From: Joe Russell-Wells
Sent: 14 December 2012 15:30
To: Neil Crowther
Subject: FP/155/12/DOC - Conditions 10, 11 and 19

Condition 10

Condition 11

KEY:

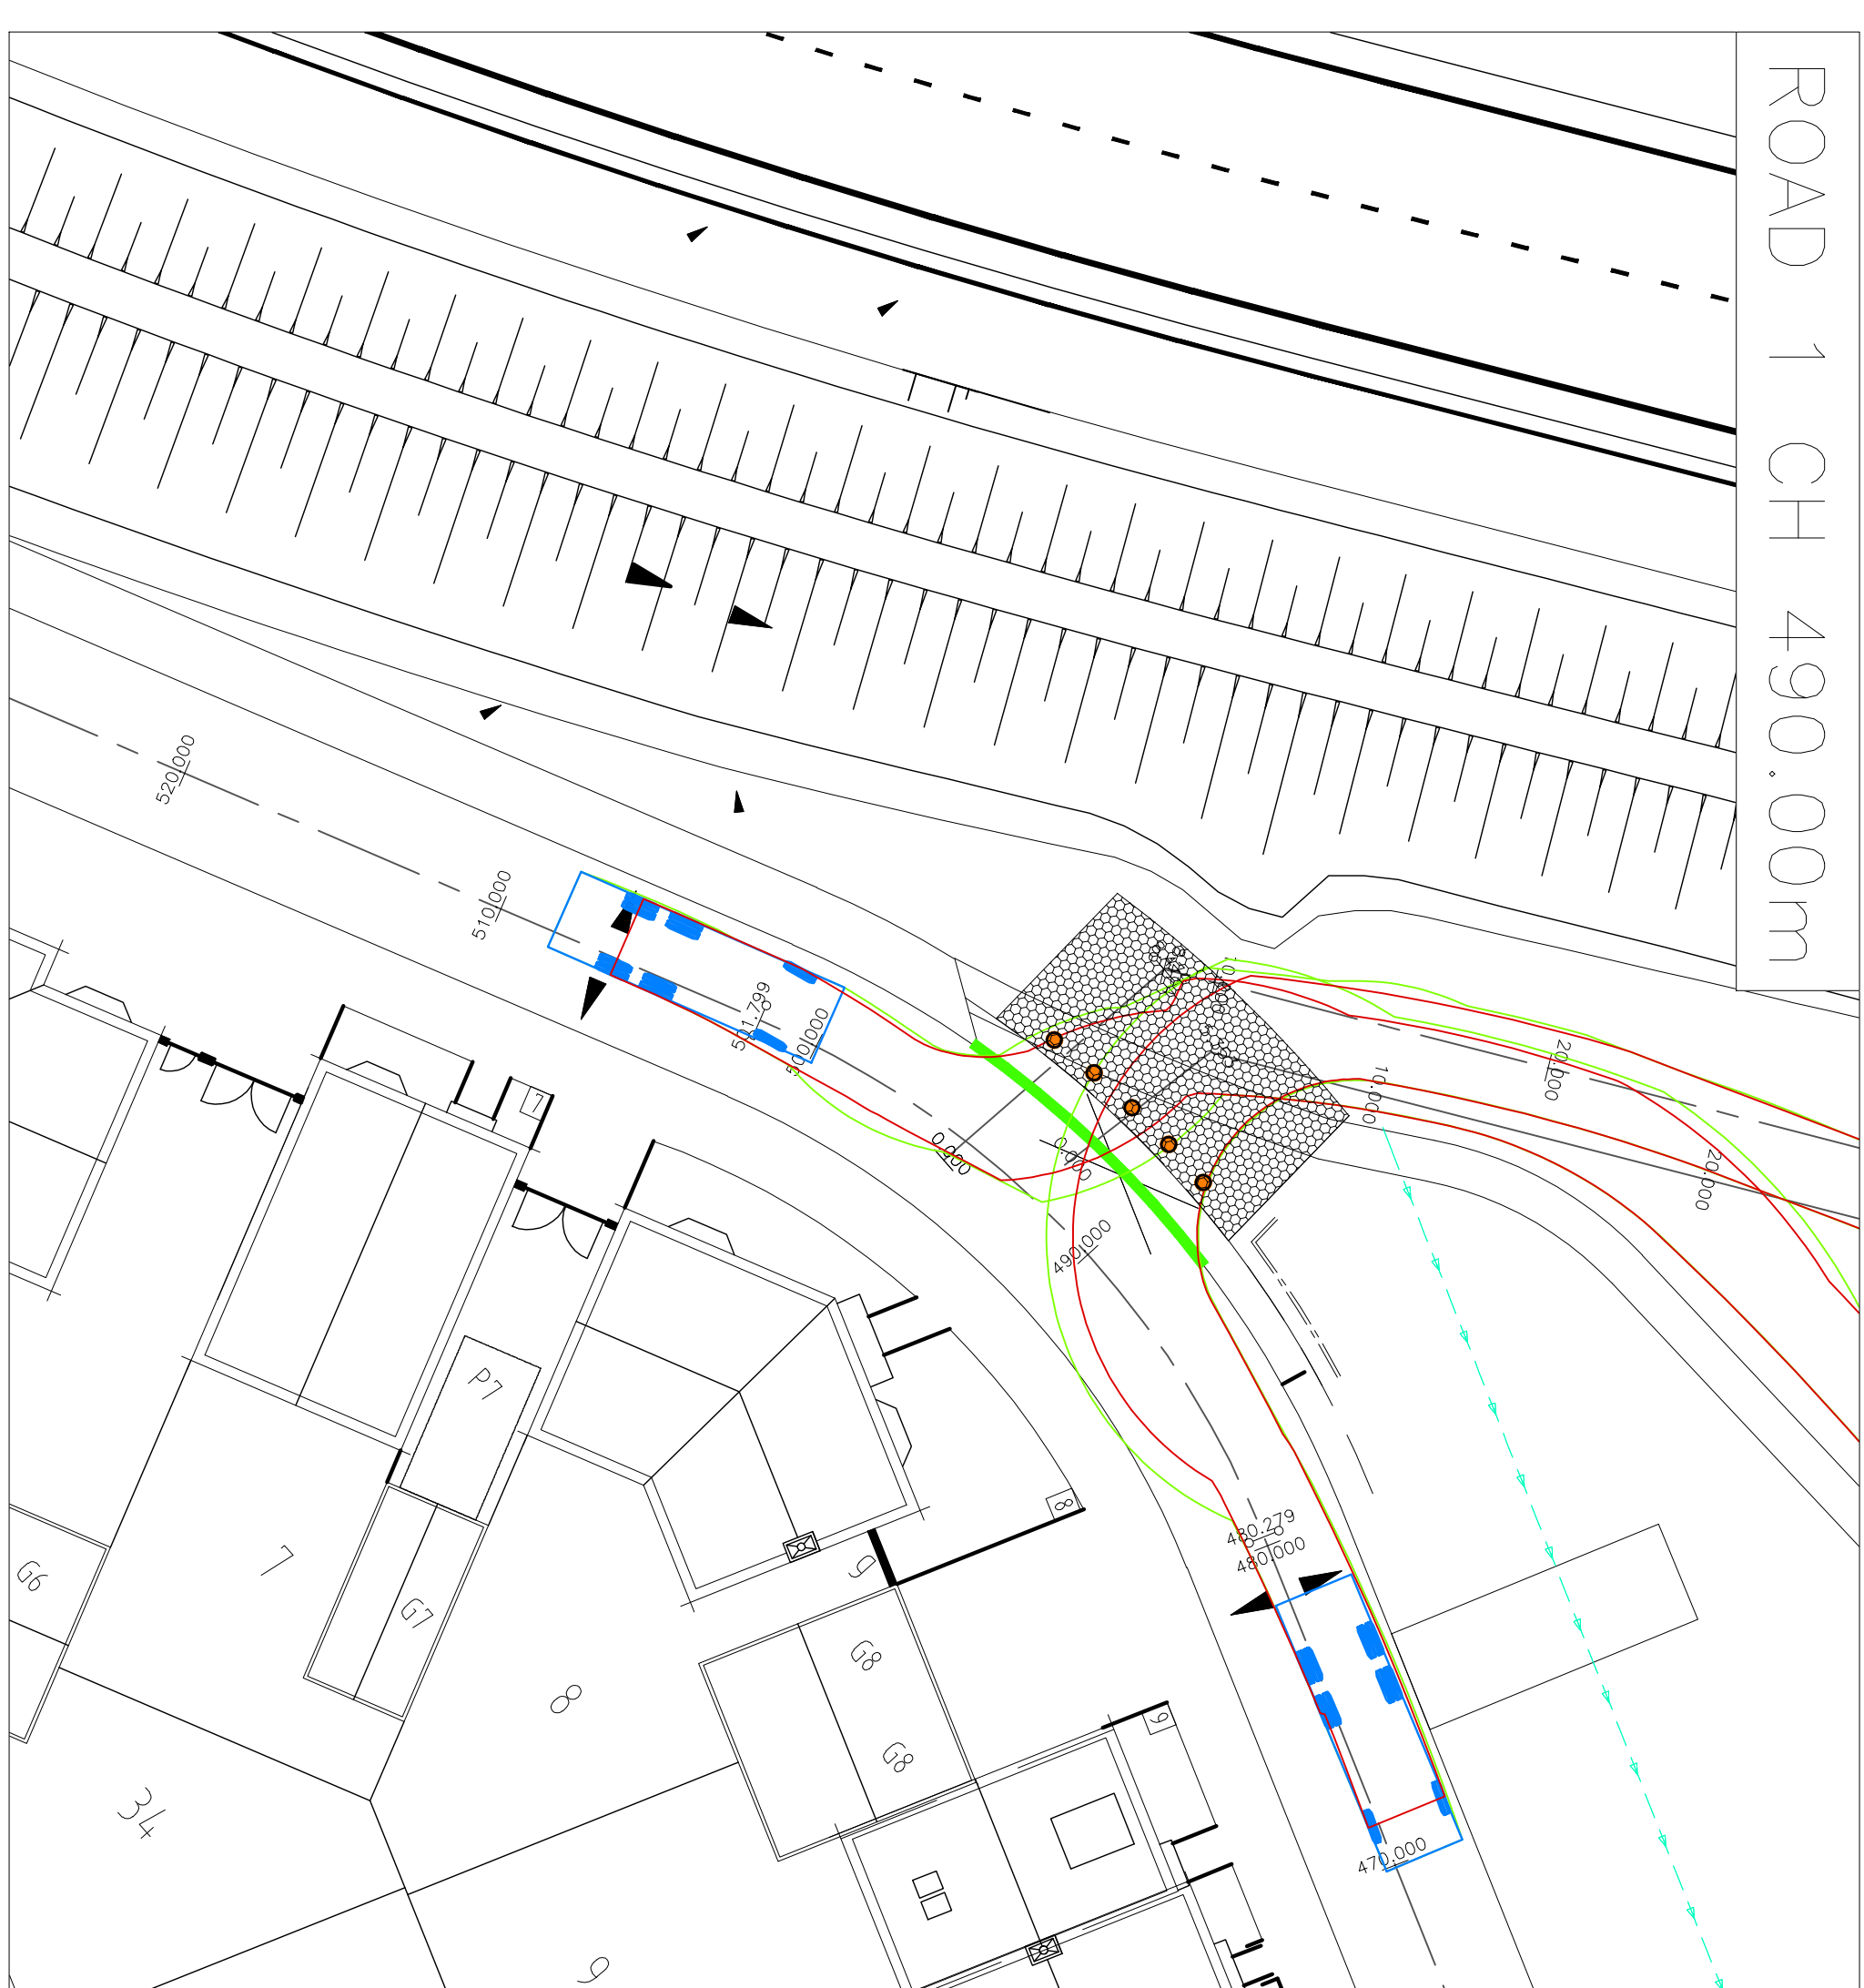
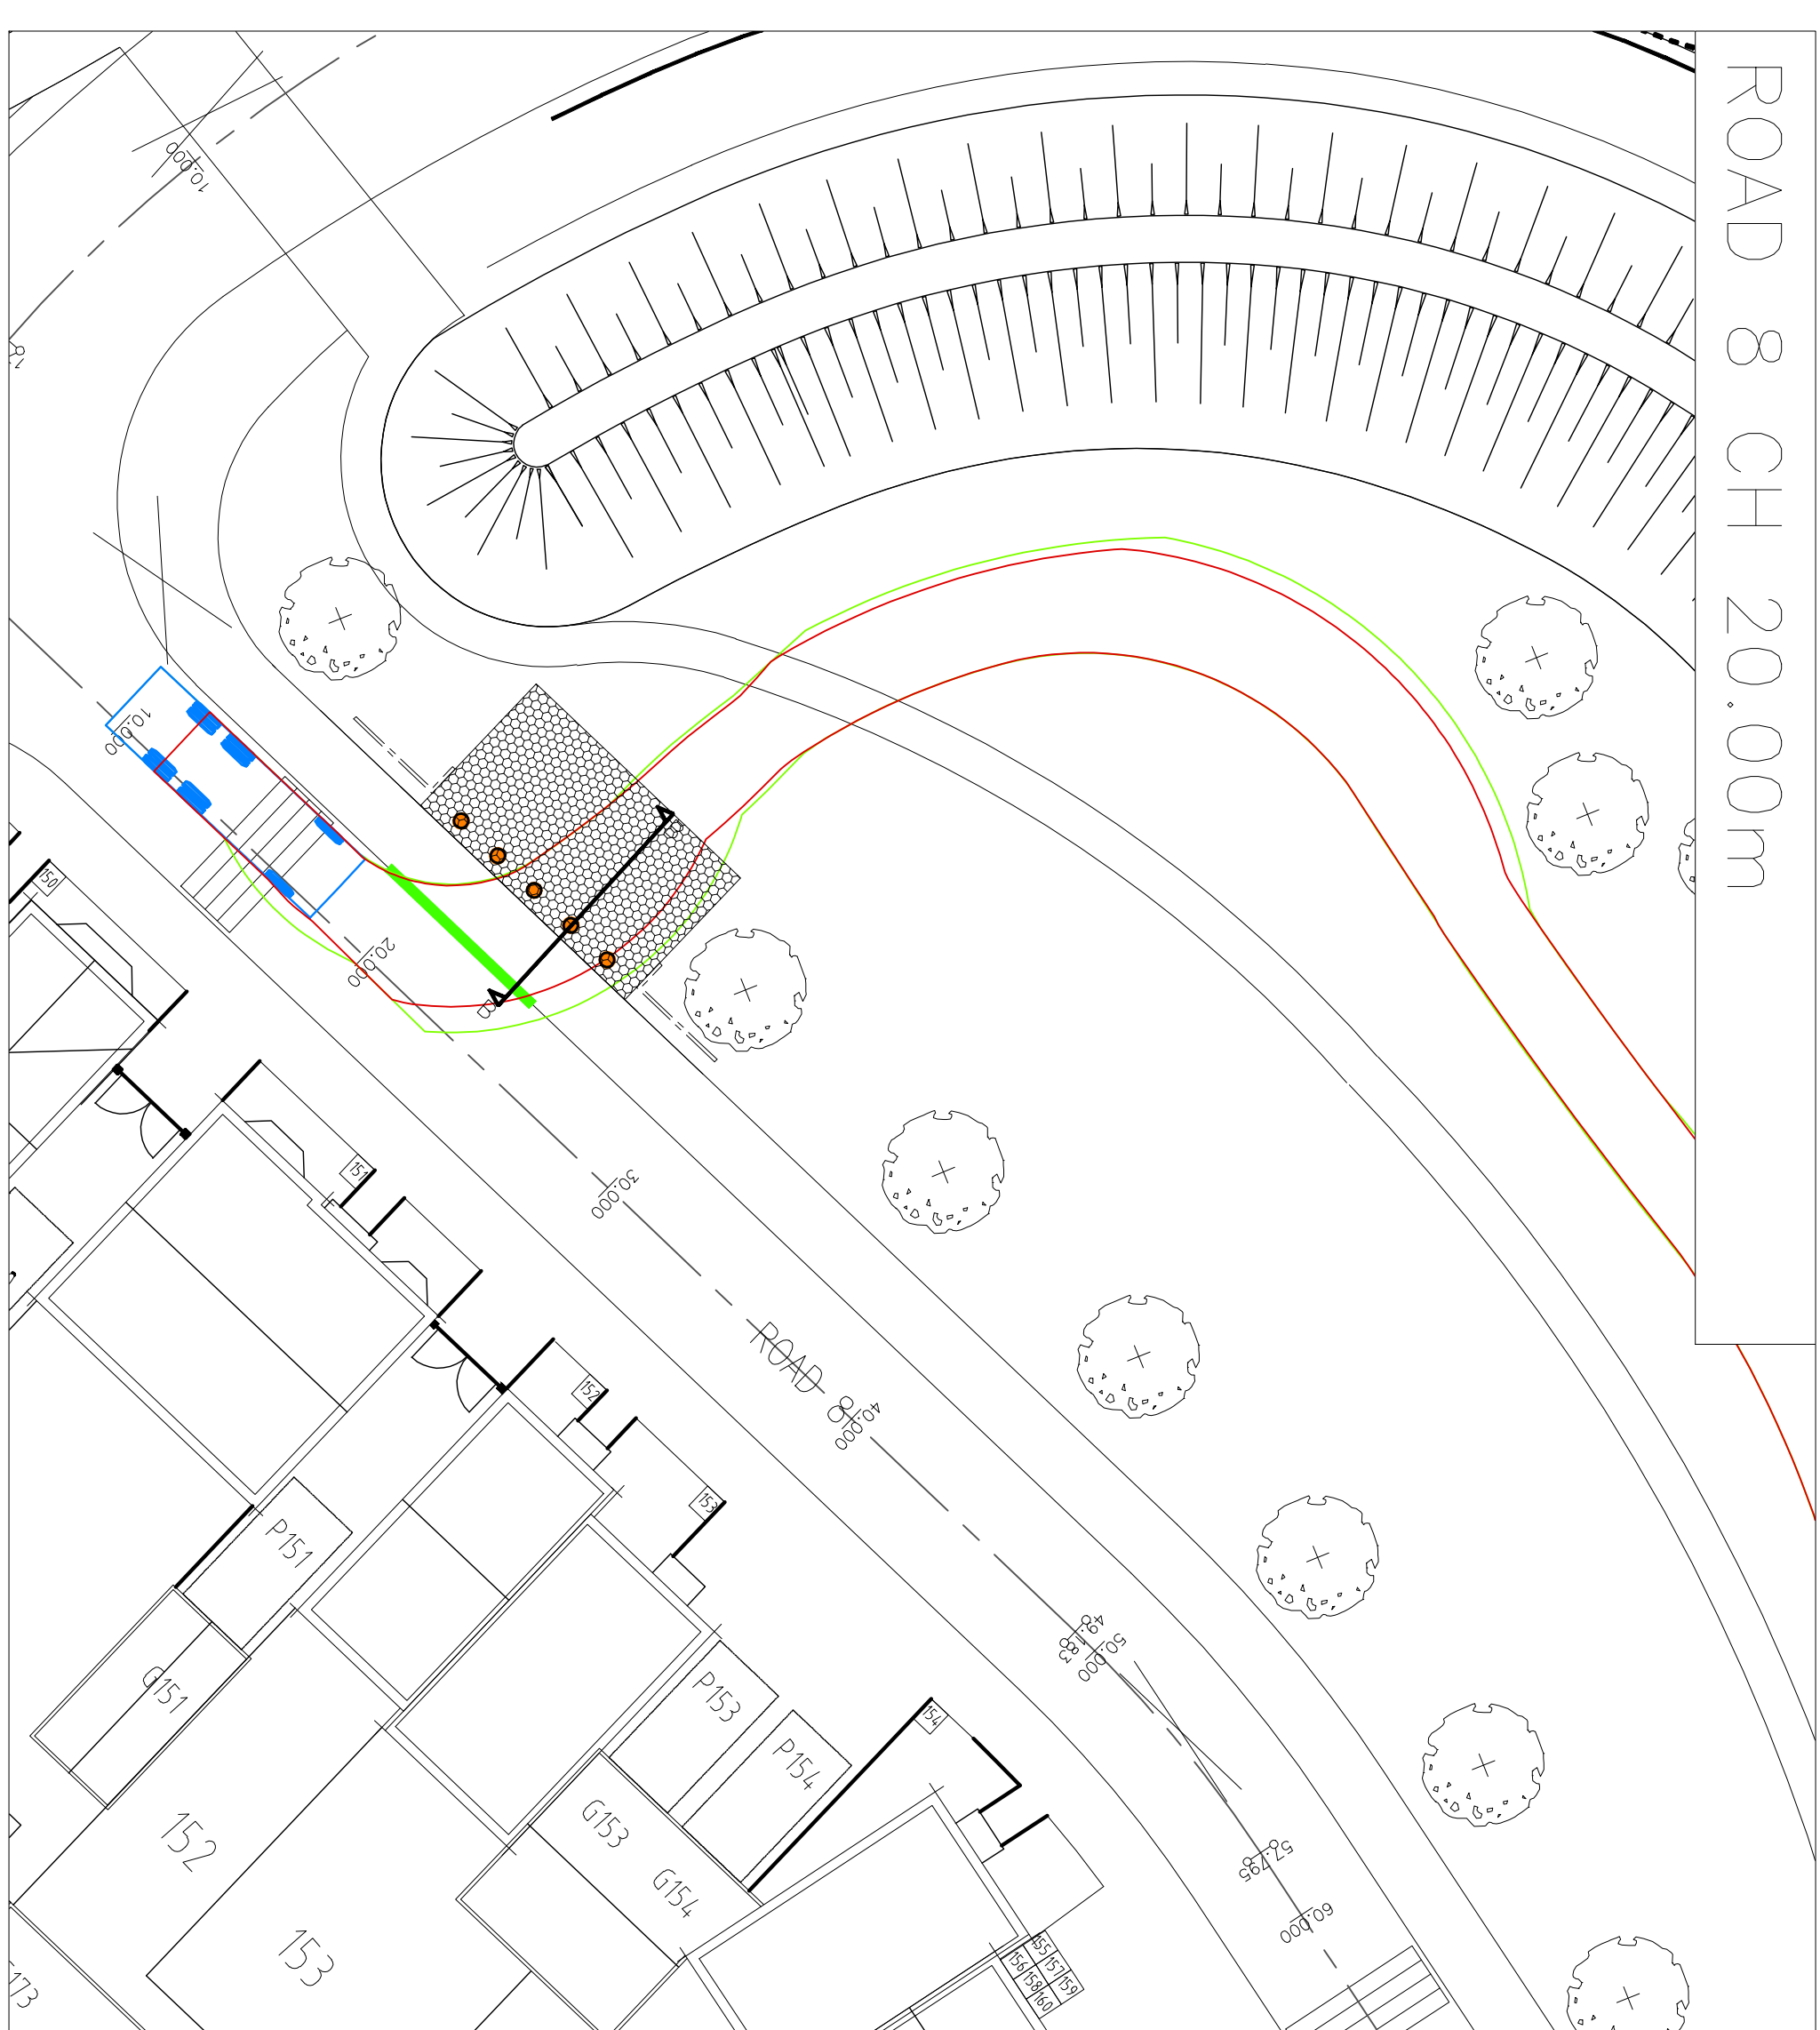
The information submitted does not prevent access by unauthorised vehicles. I do not therefore recommend release of the condition.

The trip rail detail is satisfactory; this together with previously submitted information I recommend release of the condition.
